CUMBERLAND
CITY COUNCIL

Ref: OA2020/0012

Subject: Development Application for 11 and 13 Percy Street Auburn.
Application No: OA2020/0012.
Property: 11 - 13 Percy Street Auburn.
Proposal: Ministerial Consent - SSD-10470 - Demolition of existing structures and construction of a warehouse and distribution centre to operate 24 hours a day seven days a week, with associated bulk earthworks, stormwater drainage, landscaping, car parking and signage.

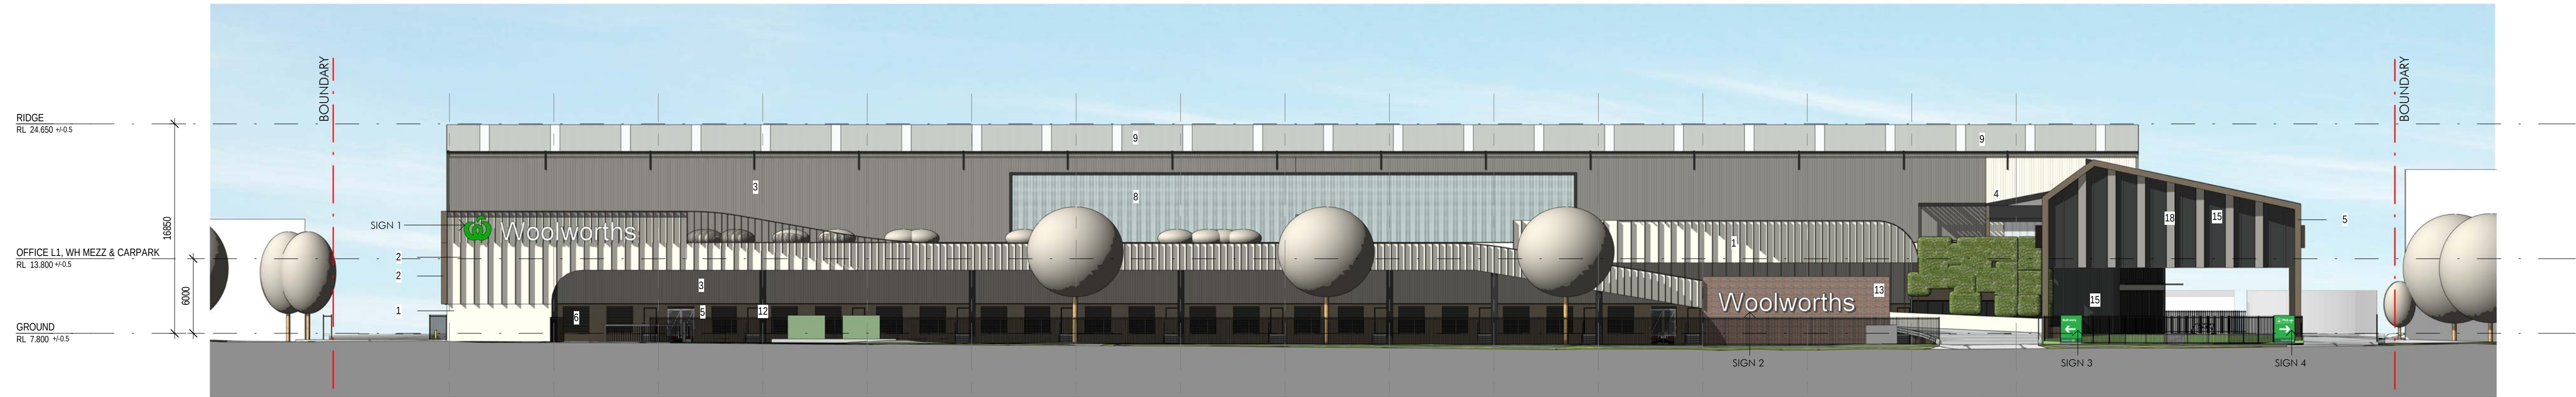
b) **Solar panel zone on roof of warehouse building**

The roof plan Drawing Number 11250-DA013 (Issue A) prepared by Nettletontribe and dated 18 September 2020 is providing an "Indicative Solar Panel Zone" across much of the roof space. Details of the solar panels to be installed across the roof space should be included into the plans. As such, this will require an additional plan showing in detail, the solar panels to be installed for assessment purposes.
